An
Coimisiún
Pleanála

Direction
ACP-324064-26

WHEREAS a question has arisen as to whether the alteration of the existing stone boundary wall on the grounds of Bishop's House, Old Dublin Road, County Carlow, for the propose of the installation of a 1.2-meter-high timber gate for the purpose of creating a new opening is or is not development or is or is not exempted development:

NOW THEREFORE An Coimisiún Pleanála, in exercise of the powers conferred on it by section 5 (3) (a) of the 2000 Act, hereby decides that the alteration of the existing stone wall, installation of a gate for the purpose of creating a new opening at Bishop's House, Old Dublin Road, County Carlow is development and is not exempt development.

Figure 2.1: Existing and proposed elevations of stone wall. (Source: Eugene Keyes c/o Bishop's House, Carlow).

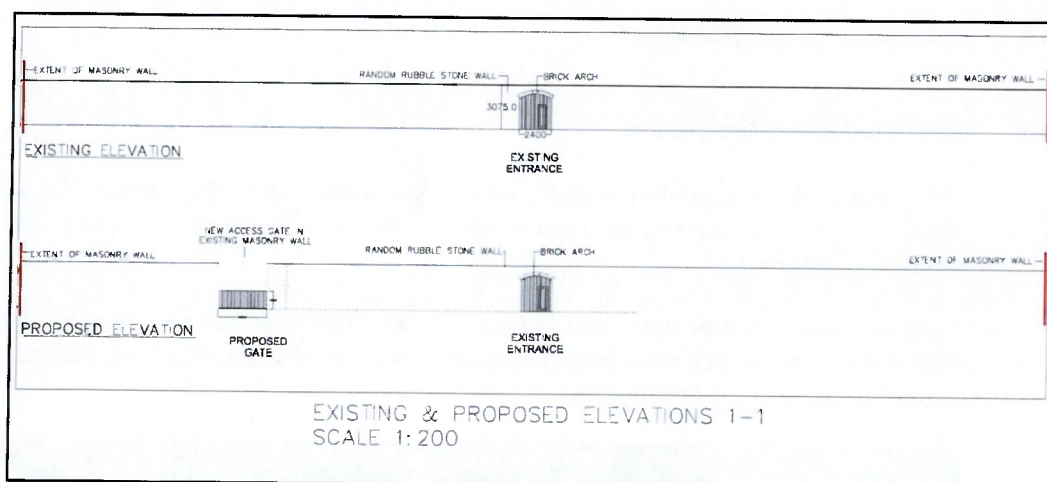
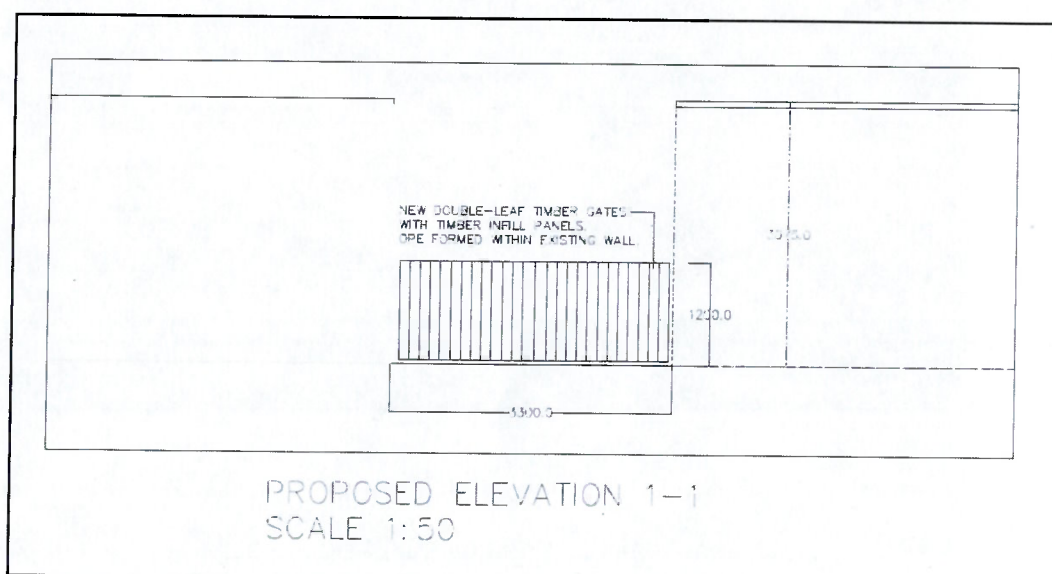
- (a) The alteration of the stone boundary wall, for the purposes of creating a new opening in the wall, constitutes the construction of a gateway which constitutes works and which in turn constitutes development within the meaning of the Planning and Development Act 2000, as amended,
- (b) The height of this constructed gateway would be 3.075m (arising from the height of the existing boundary wall and by reference to the submitted drawing number 24001-002 PL1),
- (c) The proposed gateway would not benefit from an exemption by reference to Section 4(1)(h) of the Planning and Development Act, 2000, as it would

materially affect the external appearance of the boundary wall so as to render the appearance inconsistent with the character of the remaining wall structure along the Old Dublin road frontage,

- (d) The Conditions and Limitations as set out in Column 2 of both Class 5 and Class 9 of Part 1 of Schedule 2 the Planning and Development Regulations 2001, as amended, includes a height limitation of 2m on such gateways,
- (e) As the gateway height exceeds the limitations set out in Column 2 of both Class 5 and Class 9 of Part 1 of Schedule 2 of the Planning and Development Regulations 2001, as amended, the development does not come within the scope of either Classes 5 or 9 of Part 1 of Schedule 2 of the Planning and Development Regulations 2001, as amended, or any other class or provision of the regulations.
